From: Mark Berry
Sent: 10 April 2017 13:39
To: Matthew Woodward
Cc: Highways DevelopmentControl; Steven Sampson
Subject: 2017/90207 Huddersfield Road Thongsbridge

Highways initial comments are as follows:

This is an outline planning application with access the only matter to be considered.

PROPOSED ACCESS FROM BOTH DIRECTIONS
SCALE: 1:250

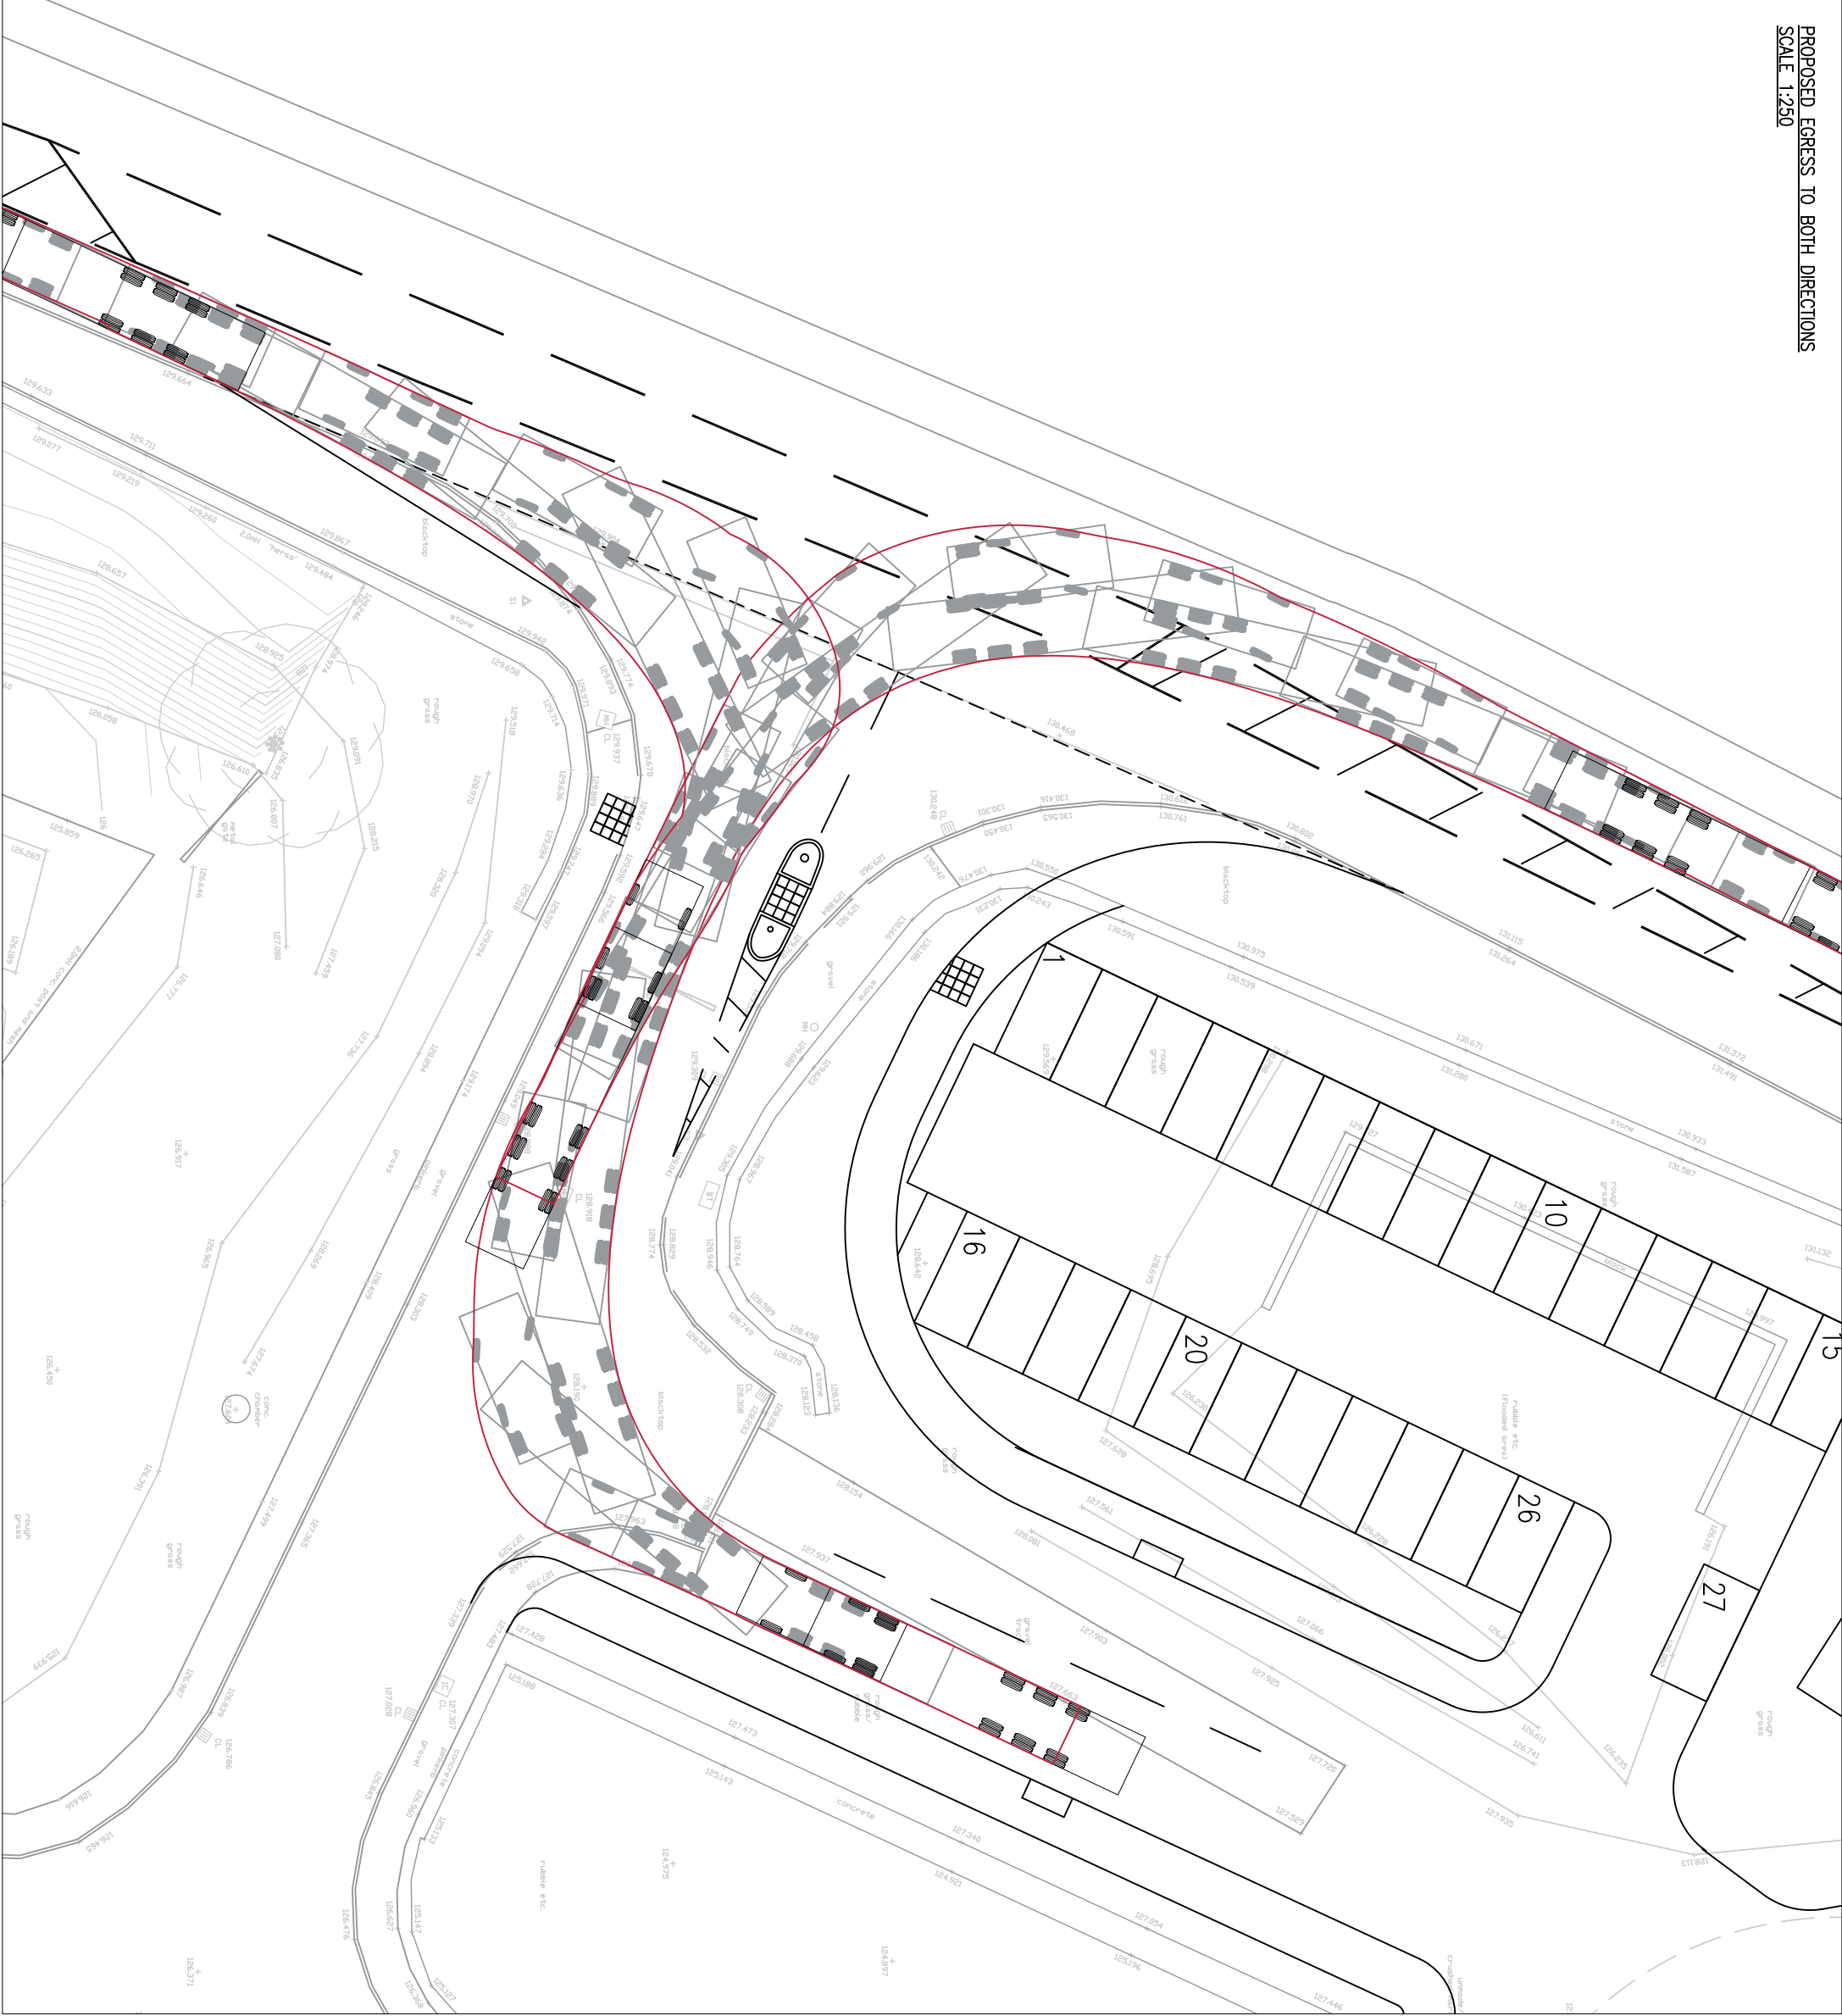
This spur was originally designed for the proposed residential use and the width and kerb radii are inadequate for industrial use. Widening this road and increasing the kerb radii moves this road closer to Huddersfield Road.

The applicants should be asked to demonstrate by means of swept paths that a 16.5 metre articulated vehicle can enter the site from Huddersfield Road in both directions and turn into and out of the proposed development site without over running adjacent carriageway.
